WEST SUSSEX COUNTY COUNCIL CONSULTATION

TO:	Arun District Council FAO: Kathryn Welch
FROM:	WSCC - Highways Authority
DATE:	11 November 2021
LOCATION:	142 Clun Road, Littlehampton, BN17 7ET
SUBJECT:	LU/300/21/HH Drop kerb and convert front garden into driveway.
DATE OF SITE VISIT:	N/A
RECOMMENDATION:	Advice
S106 CONTRIBUTION TOTAL:	N/A

Proposed domestic access
For 142 CLUN ROAD,
LITTLEHAMPTON, BN17 7ET
5.5m

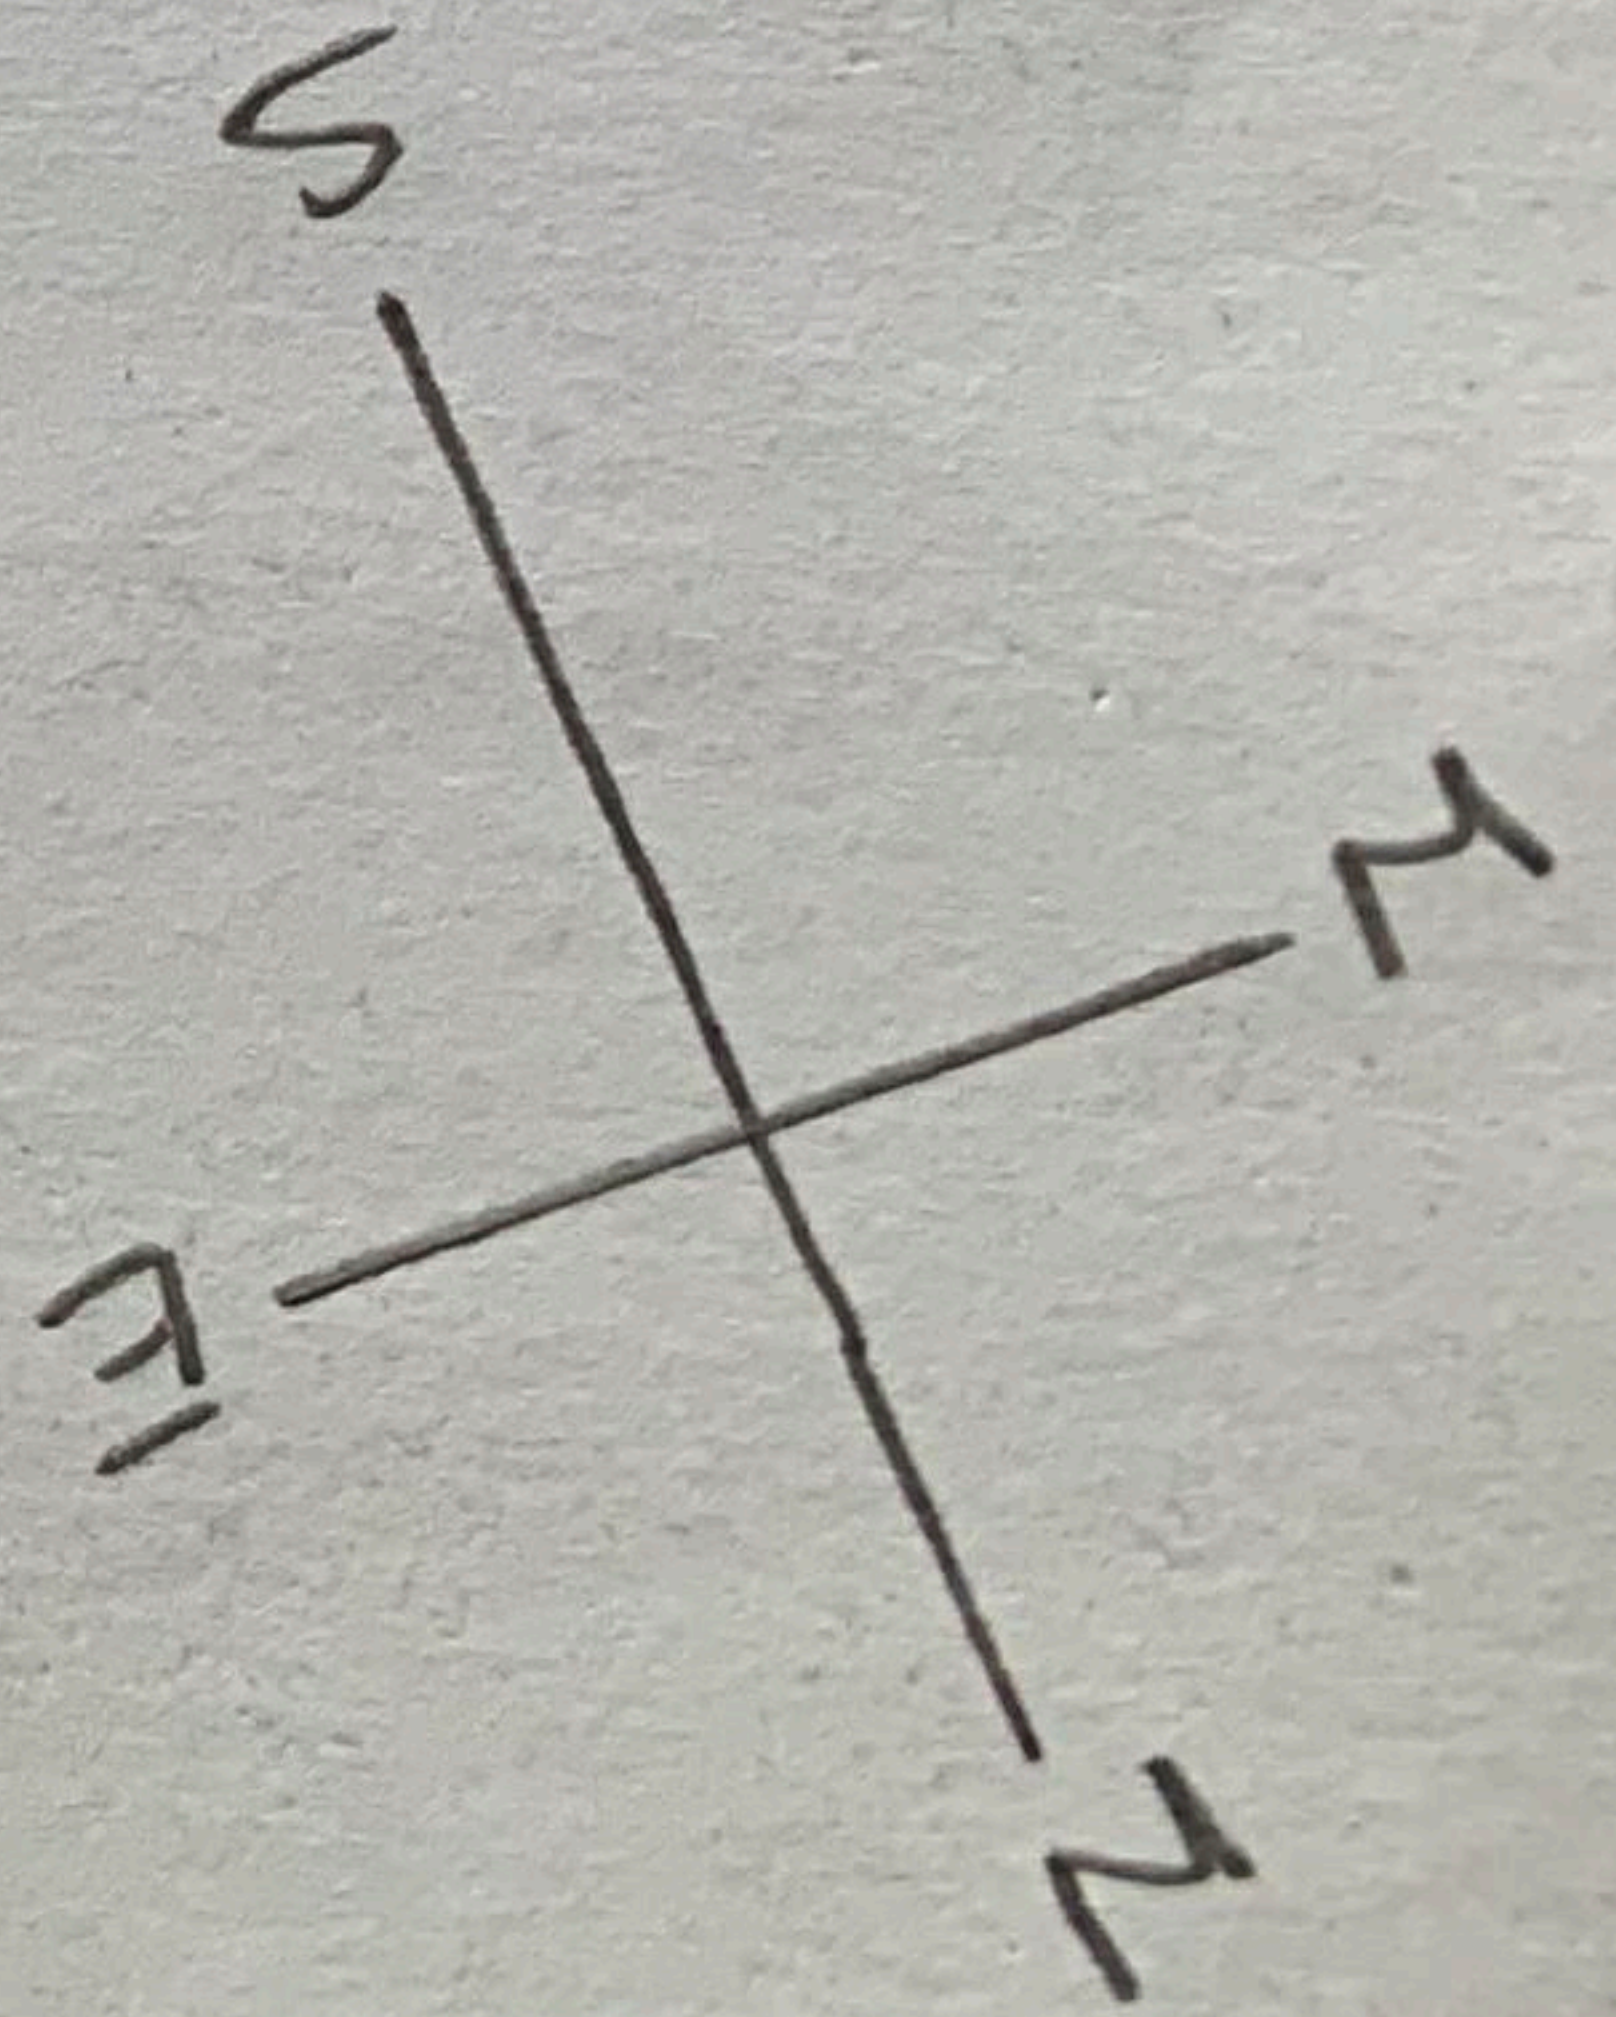
The applicant proposes a 3m wide dropped kerb onto Clun Road. The proposed vehicle crossover (VCO) will be subject to a licence obtained through the local area office and constructed to a specification agreed with the local area engineer. From inspection of the plans and local mapping, there are no apparent visibility issues with the proposed point of access on to Clun Road.

Regarding vehicular parking, the proposed area of hardstanding is of sufficient size to allow for two off-street car parking spaces. On-site turning does not appear achievable, so vehicles may have to exit the site in a reverse gear. However, the LHA does not anticipate that this would give rise to a highway safety concern, given the good forward visibility along Clun Road in this location. Neighbouring properties operate similar access arrangements with no apparent highway safety concerns.
